An
Bord
Pleanála

Board Direction BD-019814-25 ABP-314019-22

The Board decided to refuse permission for the following reasons and considerations.

**Ground Floor Plan**  
 SCALE: 1:200

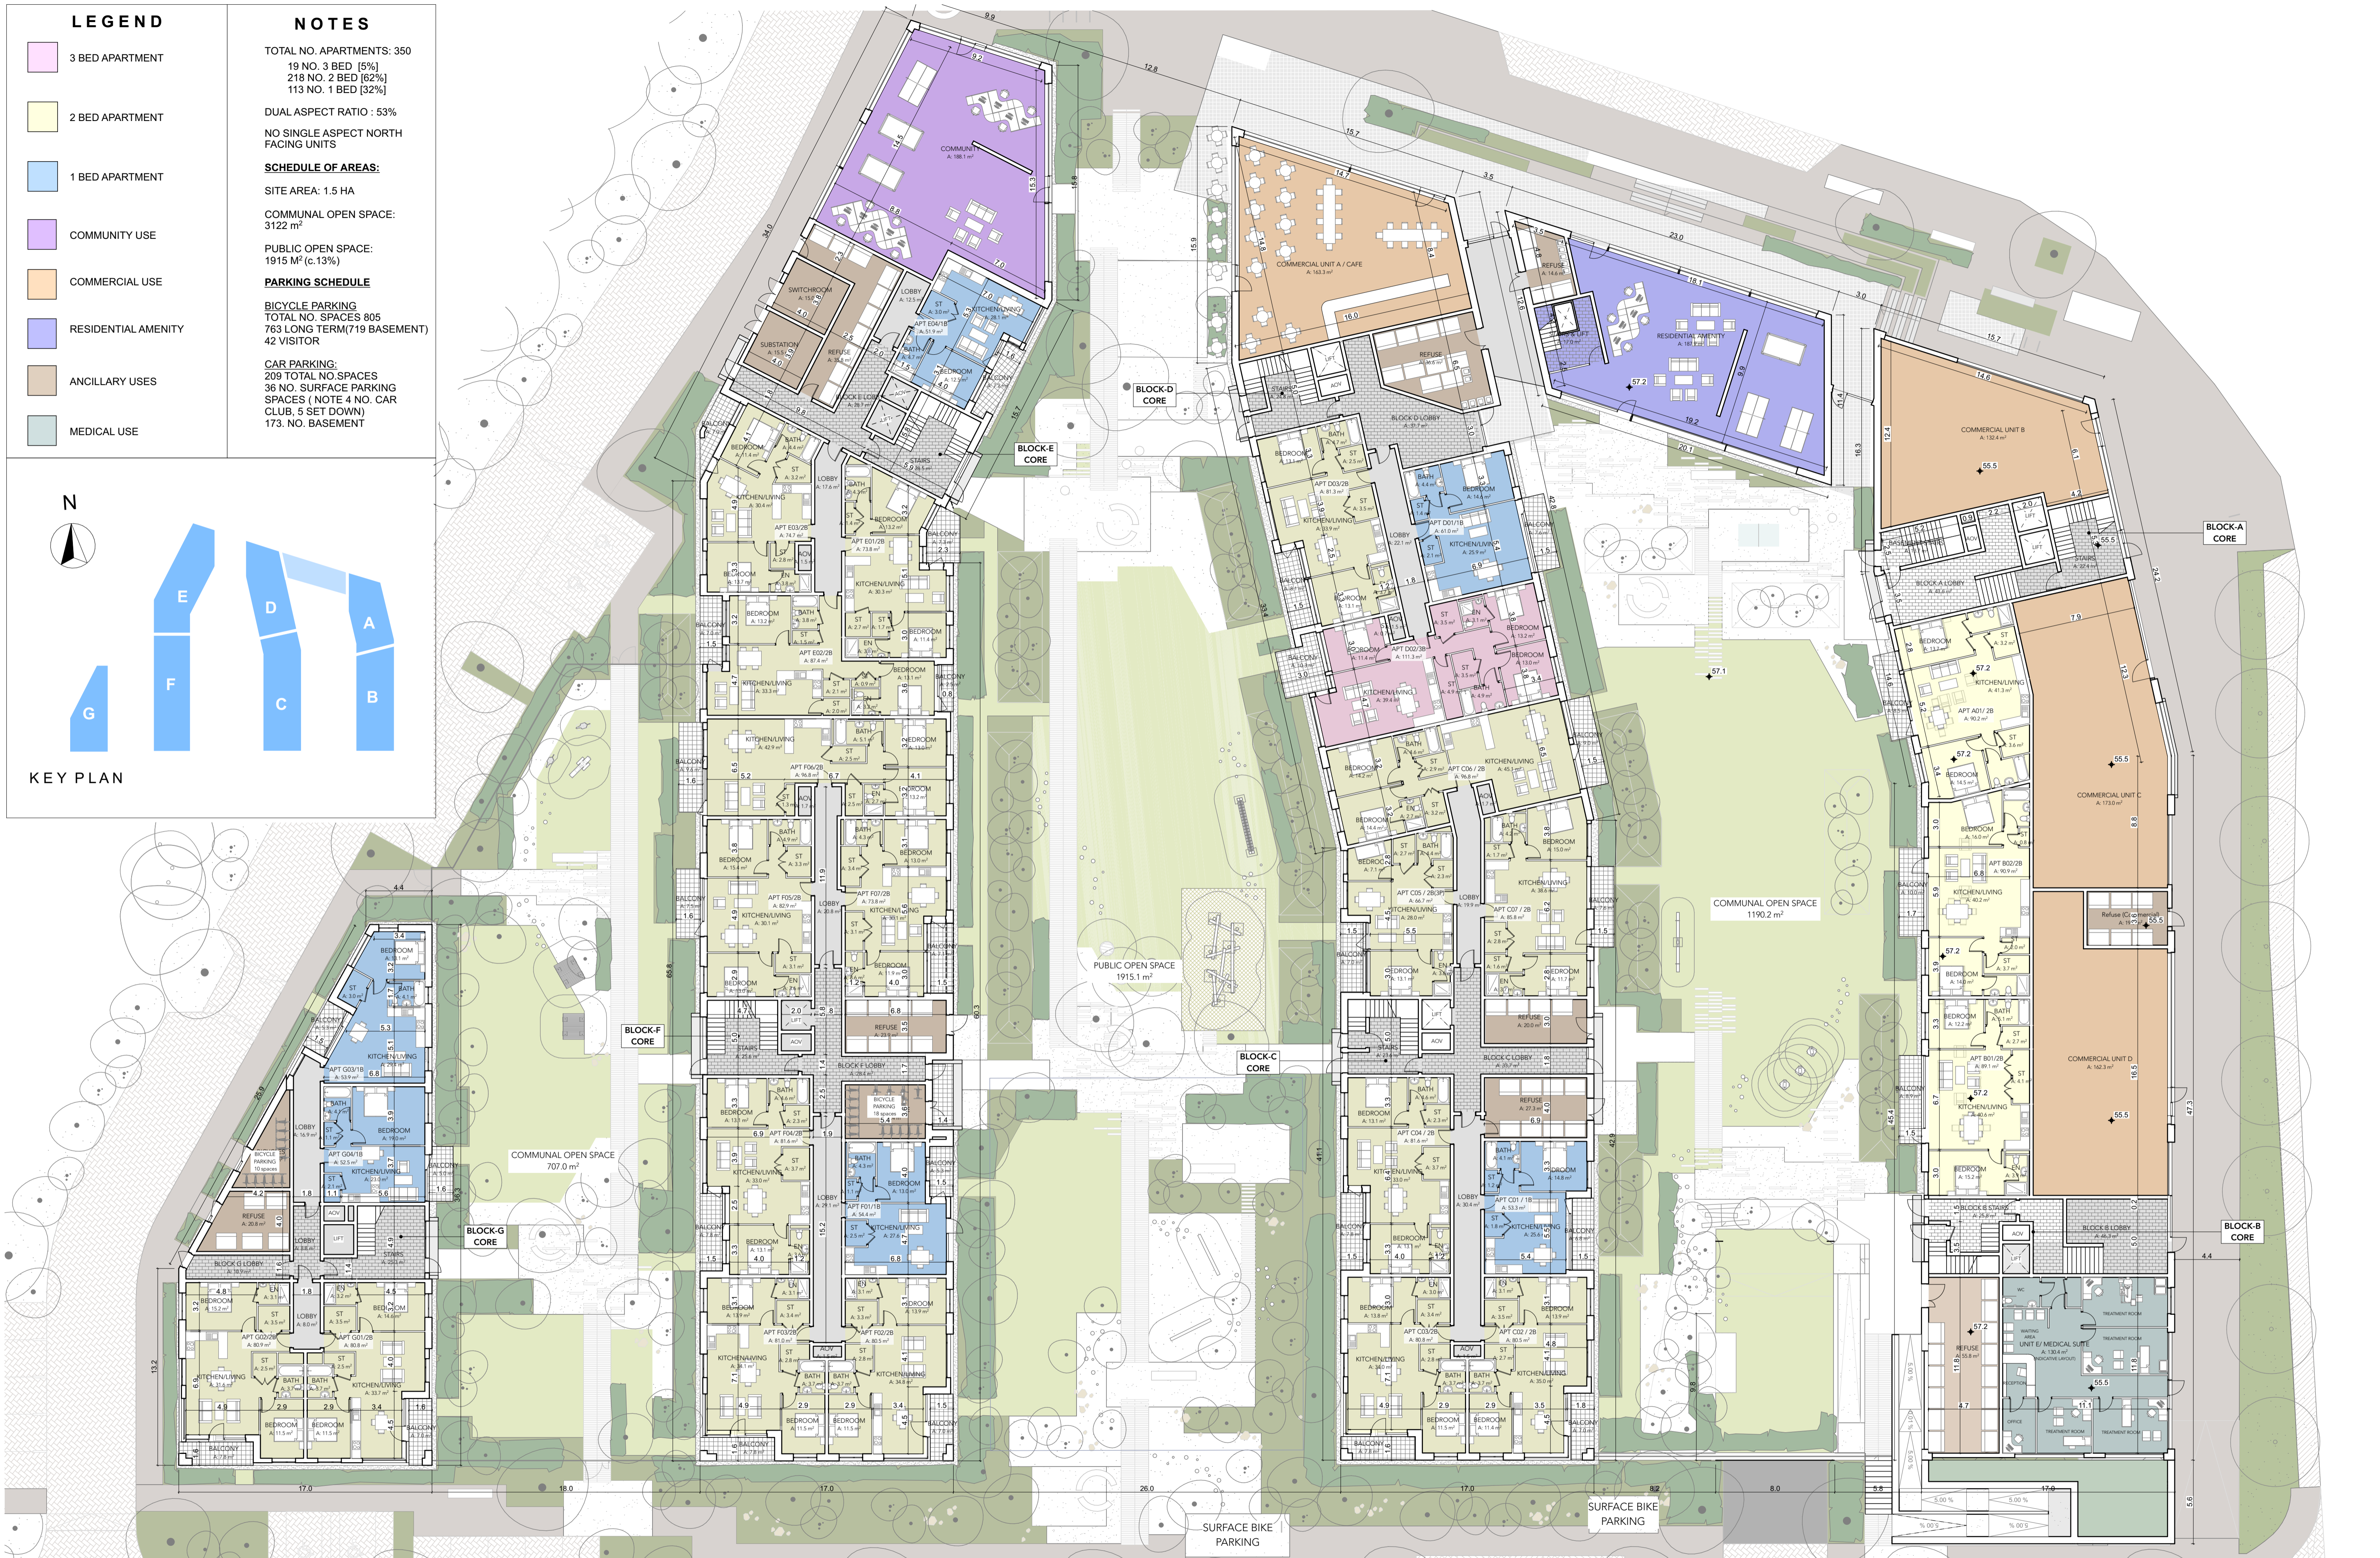
It is considered that the layout and configuration of the proposed Community, Arts, and Culture Spaces, as set out on the 'Ground Floor Plan – Oral Hearing' drawing (dated 27th February 2025), which was submitted and presented on behalf of the applicant at the limited agenda oral hearing which took place on Thursday March 13th 2025, would result in potential for public access from the community spaces in Block F to communal open space between Blocks F and G via external doors/ground floor balconies which would have a significant negative impact on the amenity of that communal open space which is intended for the sole use of the residents of the proposed development. Furthermore, it is considered that the degree of fragmentation of the proposed Community, Arts, and Culture Spaces throughout the proposed development, its potential impact on adjacent residential units, as well as the extent of the non-residential ground floor frontage onto public and communal open spaces would result in direct overlooking of communal open spaces, overlooking of adjacent residential property by members of the public, potentially low levels of activity at certain times of the day along these ground floor frontages and a reduced level of appropriate supervision of adjacent open space areas. It is

therefore considered that the ground floor layout of the proposed development, as submitted to the Board at the limited agenda oral hearing, would be likely to result in poor levels of residential amenity for residents of the proposed scheme, which would be contrary to the requirements set down at section 15.4.5 of the Dublin City Development Plan 2022-2028 (Safe and Secure Design) and the requirement, as set out in Appendix 3 of the Dublin City Development Plan 2022-2028 (Performance Criteria in Assessing Proposals for Enhanced Height, Density and Scale), to provide well connected, high quality, and active public and communal spaces, and that the proposal would therefore be contrary to the proper planning and sustainable development of the area.

In deciding not to accept the Inspector's recommendation to grant permission, the Board noted and agreed with the Inspector's concerns regarding the lack of any elevation drawings of the proposed Community, Arts, and Culture Spaces and the potential for public access from the community spaces in Block F to communal open space between Blocks F and G via external doors/ground floor balconies. The board also had a concerns regarding the fragmentation and of the proposed Community, Arts, and Culture Spaces throughout the proposed development, it's potential impact on adjacent residential units, as well as the extent of non-residential ground floor frontage onto public and communal open spaces which could result in low levels of activity at certain times of the day along these ground floor frontages and a reduced level of supervision of adjacent open space areas.
